**Application by Frodsham Solar Ltd for Frodsham Solar (EN010153)**

**The Examining Authority's second written questions and requests for information (ExQ2): Issued on 13 March 2026**

**Responses are due by deadline 5: 26 March 2026**

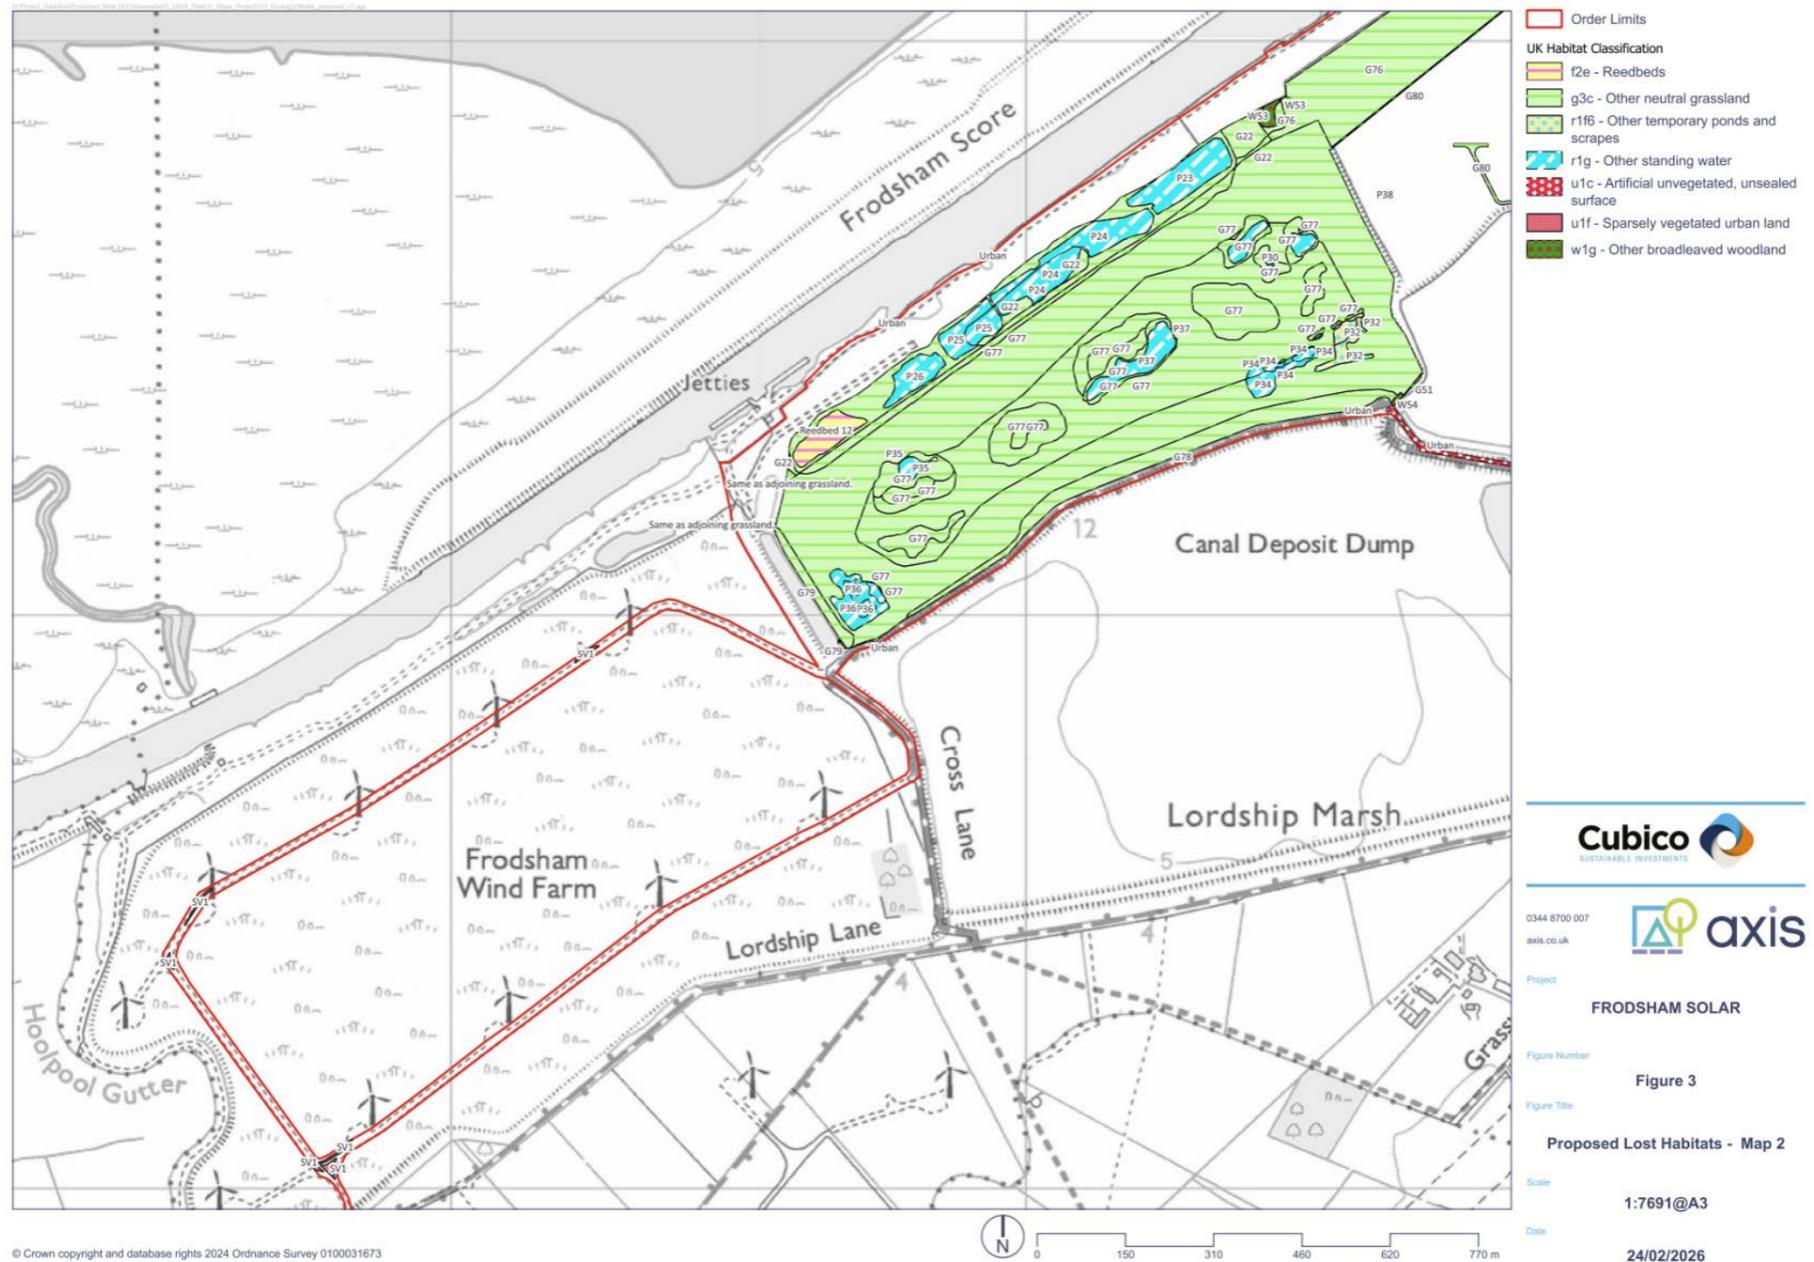
- 1) Can the applicant explain why post development there would be an increase in reedbed area but a decrease in reedbed units? What is it about the properties of the post development reedbed area that cause the calculation of resulting BNG units to fall?
- 2) The ExA acknowledges that BNG requirements are not yet mandatory for NSIP applications and that the applicant has clearly stated that the trading rules for reedbeds are not proposed to be met. Nevertheless, the mitigation hierarchy should still be adhered to. The ExA would like the applicant to explain how much reedbed is proposed to be lost for each of the areas given below and provide justification as to why these areas of reedbed are proposed to be lost and not retained:
  - a. Reedbed 12 shown in the NBBMA (see screenshot below from Map 2 of Figure 3 of the deadline 4 Biodiversity Net Gain Report [REP4-038])

- 3) Can the applicant explain why it has not proposed more areas of reedbed to be retained or the creation of more reedbed habitat to achieve at least a no net loss? Would this be possible? If not, explain why not.
- 4) Can the applicant explain why it has not proposed more areas for the retention or creation of scrub broad habitat to achieve at least a no net loss? Would this be possible? If not, explain why not.
- 5) Can the applicant explain how it has adhered to the principle of the mitigation hierarchy in relation to these two habitat types (reedbed and scrub broad habitat)?
